PJ JW
S6/2012/2622/LB

re: Planning Applications Received by Welwyn Hatfield Council

Application No.	Description and Location	Applicant/Agent
S6/2012/2622/LB 2622	Erection of a single storey rear extension following demolition of existing ground floor extension and enlarged terrace area Oshwal Association of the UK Oshwal Centre Coopers Lane Road Northaw Potters Bar EN6 4DG	Mr P Johnson DLP Planning Ltd 4 Abbey Court Priory Business Park Fraser Road Bedford MK44 3WH

Drawing no. 6842/03/PO – Existing and Proposed Plans and Elevations

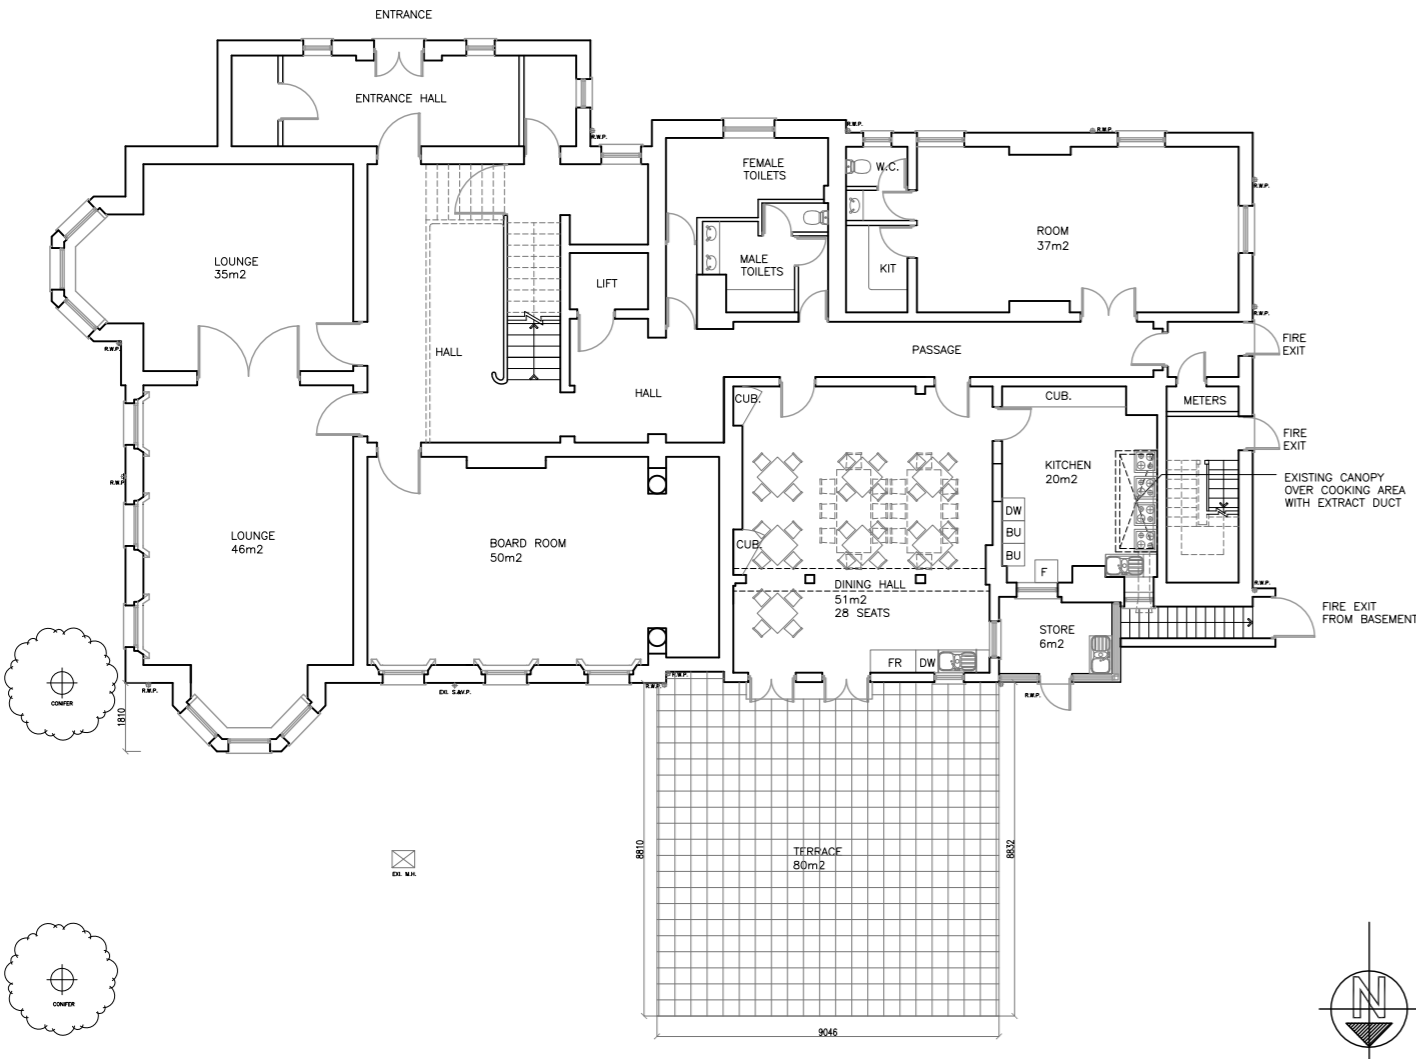
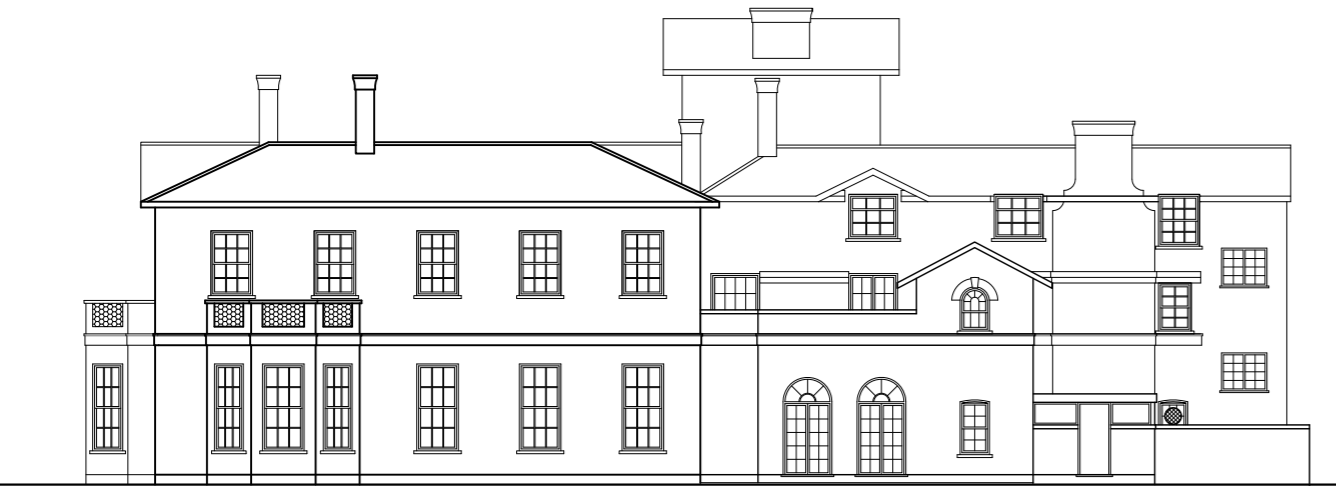
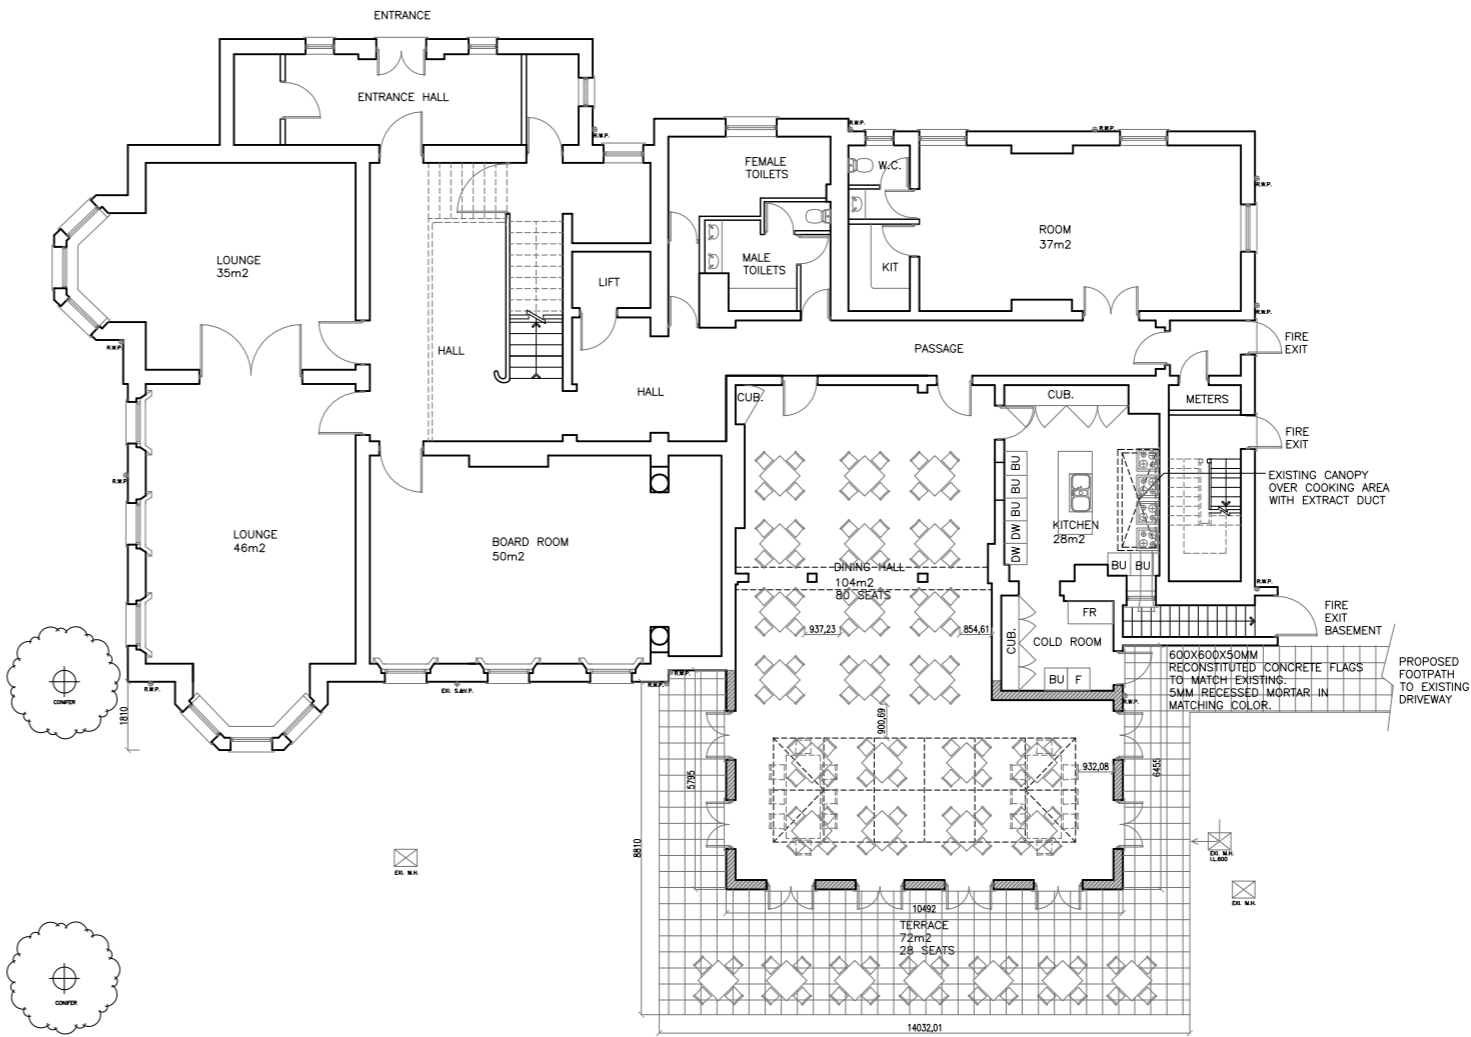
We note the proposed layout of the ground floor and the location and provision of toilets. Can you confirm where the wheelchair accessible toilet is located and the maximum travel distance from the proposed new dining area? Whilst we have downloaded A4 copies of the drawing we cannot determine any measurements.

We also note the indicative dining room layout. Please confirm if the tables and chairs in the dining area are fixed or moveable and there is adequate circulation space. We would remind you that a 750mm turning circle is required for a self-propelled wheelchair.

We further note the proposed layout of the serving area and cannot determine if there are any reduced height spaces for wheelchairs.

From the drawing we are unable to determine if there is level access at all entrances/exits. Could you kindly advise details of same?
